**Rezoning Transportation Analysis**  
**Petition Number: Insert Zoning Petition #2021-036**  
*General Location Identifier: Tax ID 06306125*

| Date     | Description        |
|----------|--------------------|
| 7-26-21  | Fourth Review (KP) |

RZ-1

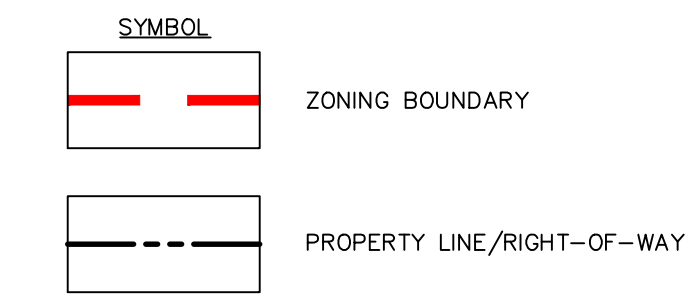
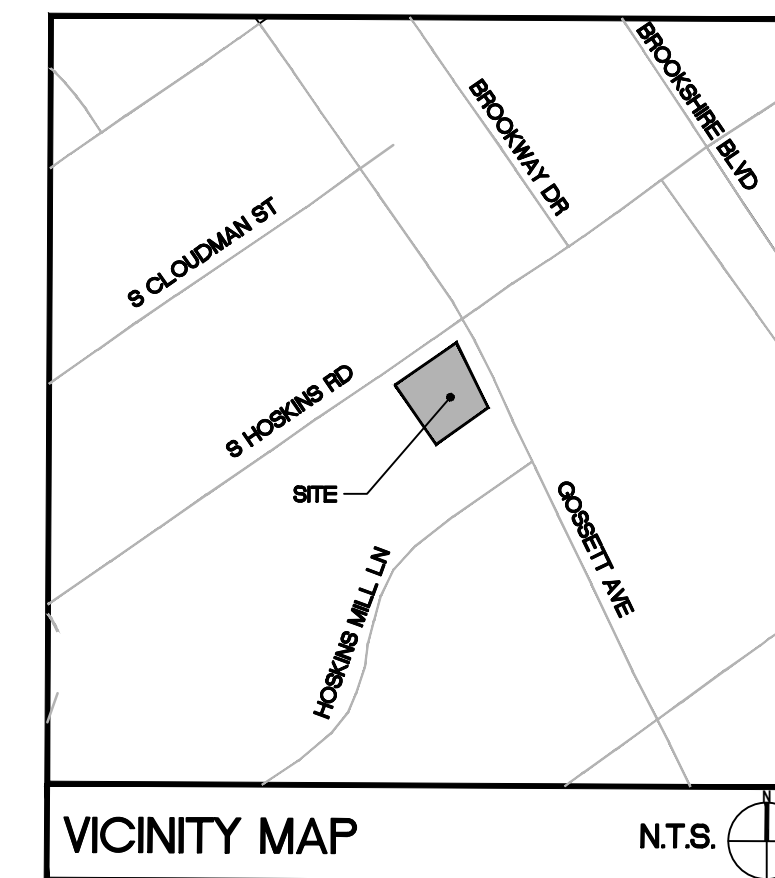
3. ~~**Update to comment (site plan dated 05.17.21):** meander the sidewalk to preserve existing trees. Sidewalk may be contained within a sidewalk utility easement 2 feet from proposed back-of-sidewalk, where located outside of the public right of way. Revise the site plan and conditional note(s) to commit to construct an 8-foot planting strip and 6-foot sidewalk on South Hoskins Road, labeled and dimensioned from the road centerline and future curb line location, in support of the Charlotte WALKS Council adopted policy. Replace the existing accessible ramp at the intersection with two standard CLDSM PROWAG directional ramps.~~
